Lucinda Craig
Planner
Department of Planning and Environment
PO BOX 404, PARRAMATTA NSW 2124

Response to Submission comments for Intercontinental MOD 2 - Insertion of Stage 1A (SSD-7693-Mod-2)

Thank you for your referral received 5 May 2022 inviting comments from the Heritage Council of NSW on the above State Significant Development (SSD) - Response to Submissions (RtS).

Figure 1: Section A for Stage 1a Transport House Function Room Envelope by Coffee Parker, Drawing number 3101 dated 7 December 2021².

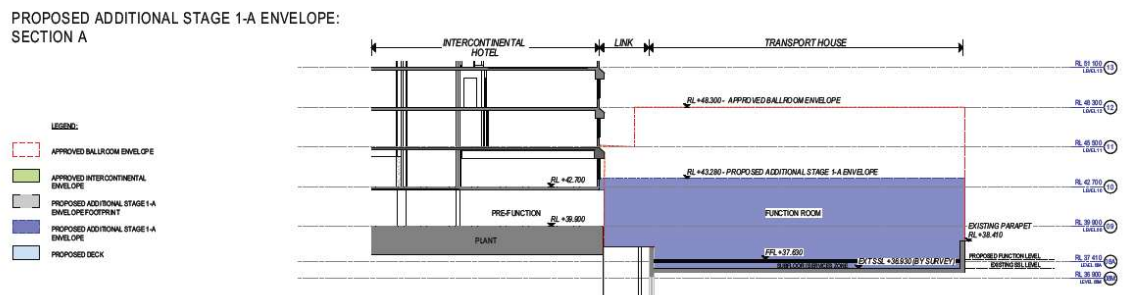
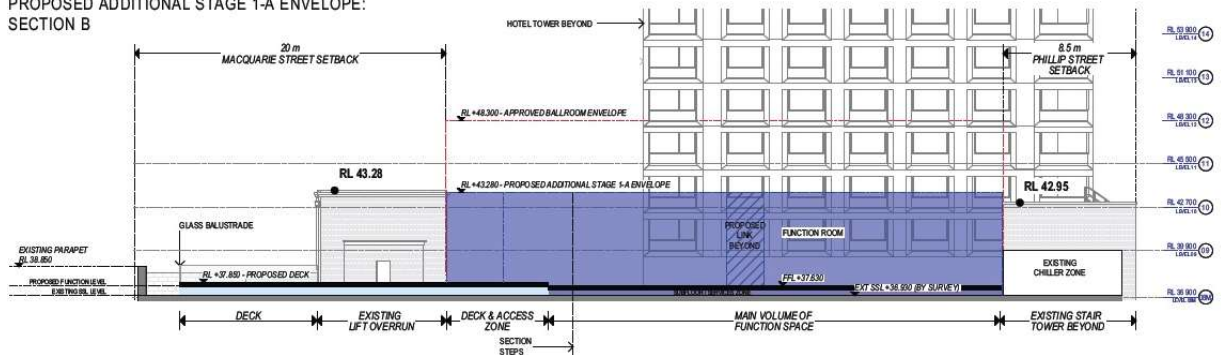
- Proposed deck and its setback from the building parapet - There appears to be discrepancy between the setback shown in the submitted plans and as noted in the Heritage RtS letter. The *Proposed Level 10 Floor Plan* (Dwg No. 2003 Issue A dated 7/12/2021) prepared by CotteeParker indicates a setback of approximately 2.3m, whereas the Heritage RtS describes this as 2.9m. It is considered that even a 2.9m setback is likely to have an adverse heritage impact. In the absence of a detailed visual analysis and assessment of heritage impact of all the elements associated with the proposed rooftop bar, establishing a setback as part of this stage is not advised. Therefore, it is recommended that the approval of the proposed deck is deferred to the detailed SSDA stage so that a more informed decision can be made based on additional information as noted above.
